**VIKING CCS PIPELINE – EN070008**

**Section 51 advice regarding draft application documents submitted by Chrysaor Production (UK) Limited**

Chrysaor Production (UK) Limited submitted the following draft documents for review by the Planning Inspectorate as part of its Pre-application Service<sup>1</sup> on 1 August 2023:

Scale	1:2,500	DO NOT SCALE	
Sheet Number	35 OF 36	Original Sheet Size	A1
Penspen No.	20428	Revision	6
Penspen Drawing Number	20428-PL-PLN-000-0002	Rev	6
Harbour Energy Drawing Number	PEN-GEN-P-XX-X-EN-108-00002-00	Rev	D6

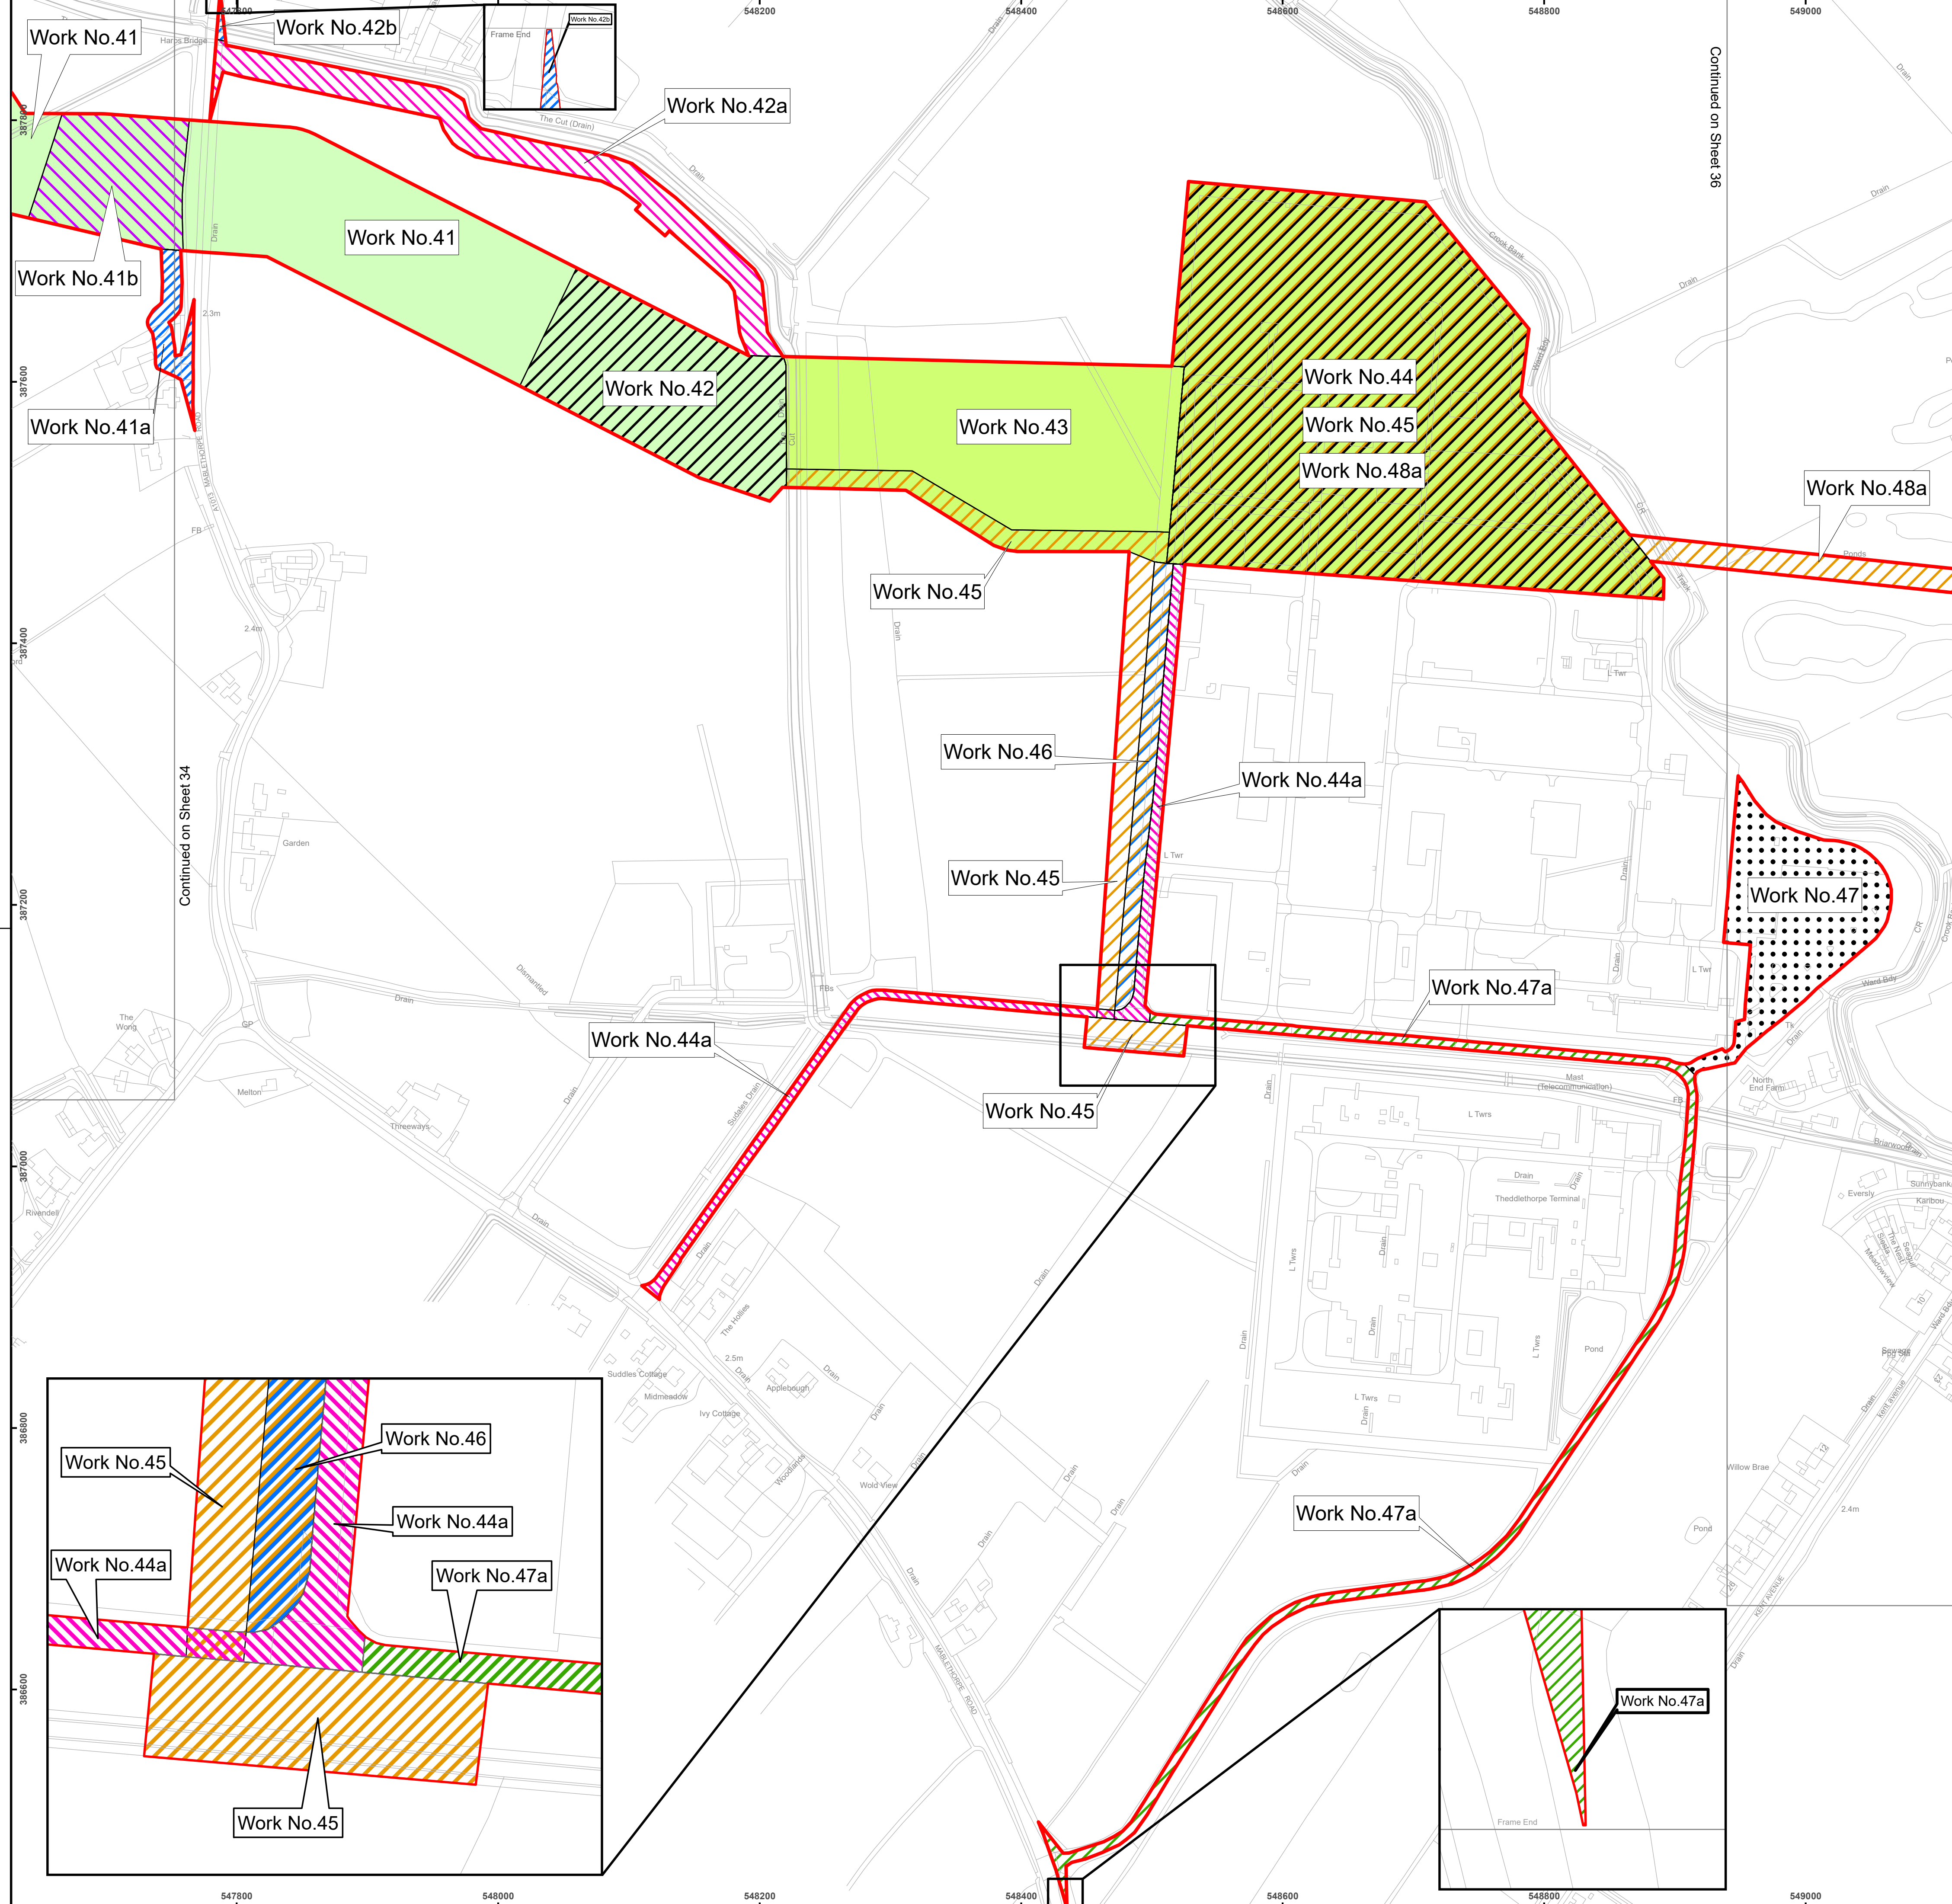
<b>66.</b>	<b>Sheet 35</b>	The entirety of red line boundary should be clearly included on all sheets (Works 42b and 47a should be reviewed).	The Applicant has amended the Works Plans [APP-014 and APP015] to include insert images showing full extent of the Order Limits.
<b>67.</b>	<b>Sheet 36</b>	With reference to the existing pipeline shown on sheet 36 which is shown to stop to the east of the Theddlethorpe terminal, it is not clear how works up to an including the Theddlethorpe terminal from the west are proposed to connect into this, as the only works shown between the terminal (Works 42-45) and existing pipeline is work 48a (electrical connection), with no reference to the pipeline or connection within this. The works plans should clearly show the entire Proposed Development, with particular reference to demonstrating the connection point between the Viking CCS pipeline and	The text in the legend has been re-worded for clarity.  The need to include the existing LOGGS pipeline within the order limits but not require works to be undertaken in the construction period is explained in paragraph 6.1.16 of
